Your Ref :
Our Ref : AL/58/07/TEL

Prior notification for 12m monopole designed to reflect a telegraph pole and associated equipment cabinets
Junction of Westergate Street and, Meadow Way, Westergate, Aldingbourne,

NOTICE OF DECISION

Designed DP	Checked RM	Date 22/01/07
Drawn RPH	Approved DST	Scale AS SHOWN
DRAWING No.	106116-01	REVISION B

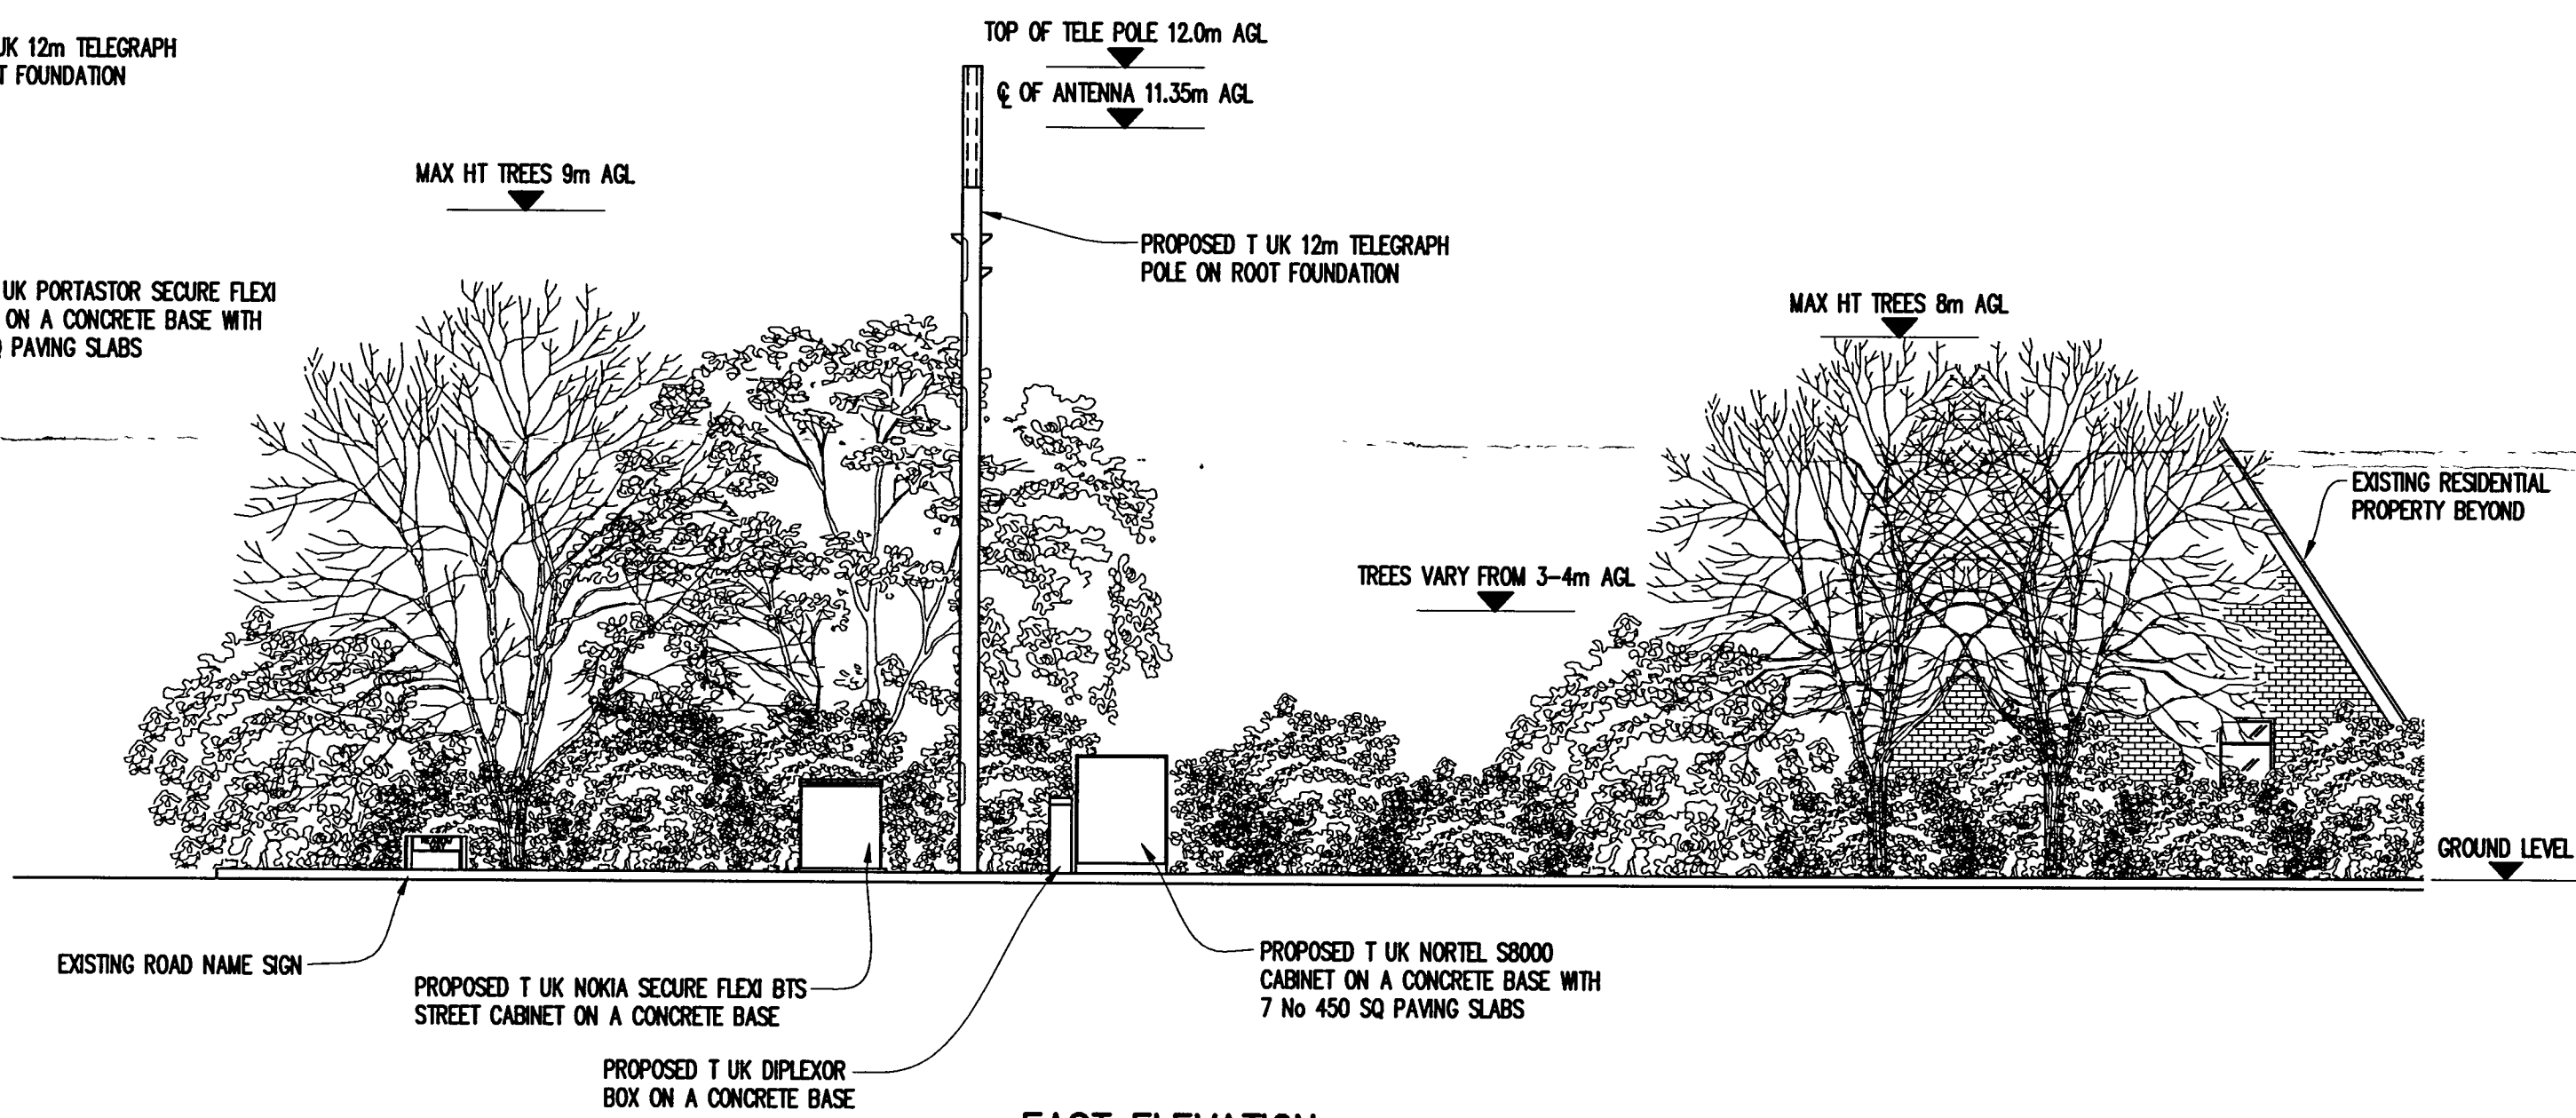
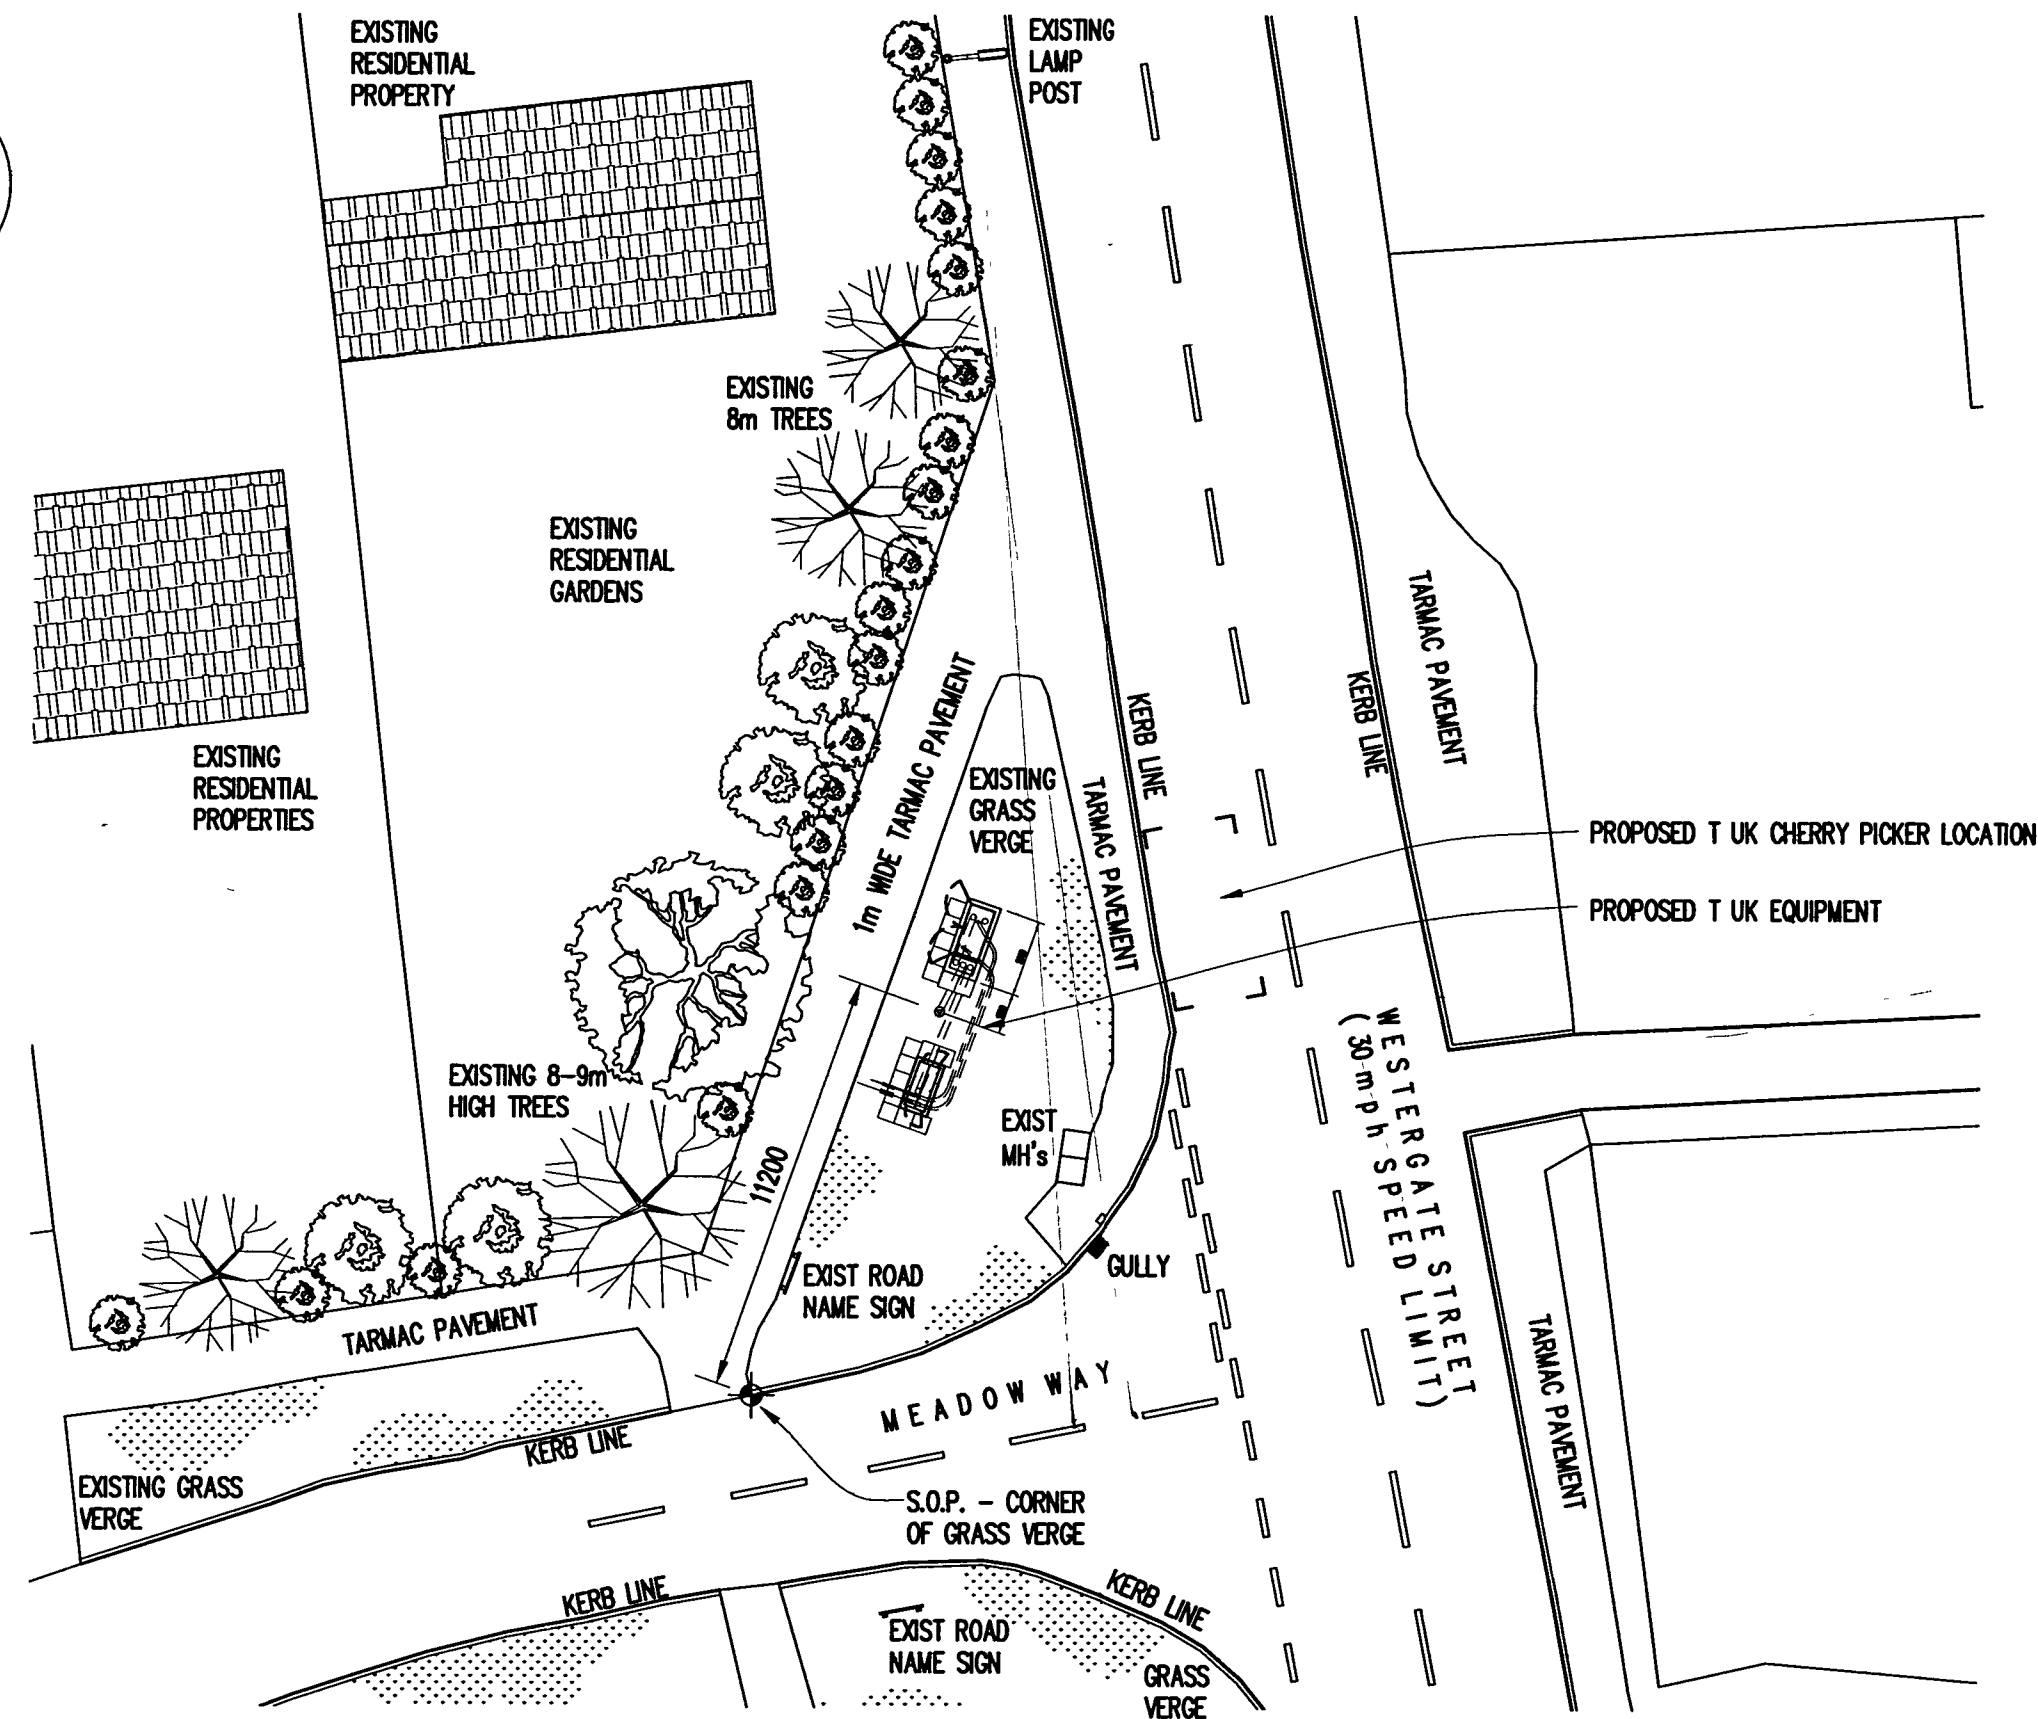
- 1 The proposed siting of the equipment would result in a prominent and obtrusive feature in the street scene which would adversely affect the visual amenities of the locality in conflict with policies GEN7 and DEV41 of Arun District Local Plan and policies DEV1 and NE23 of West Sussex Structure Plan.
- 2 Alternative sites (including those which are a greater distance away from schools) have not been fully explored, and it has not been satisfactorily demonstrated that this is the most appropriate location for the installation. The proposal therefore conflicts with policies NE23 of West Sussex Structure Plan and DEV41 of Arun District Local Plan.
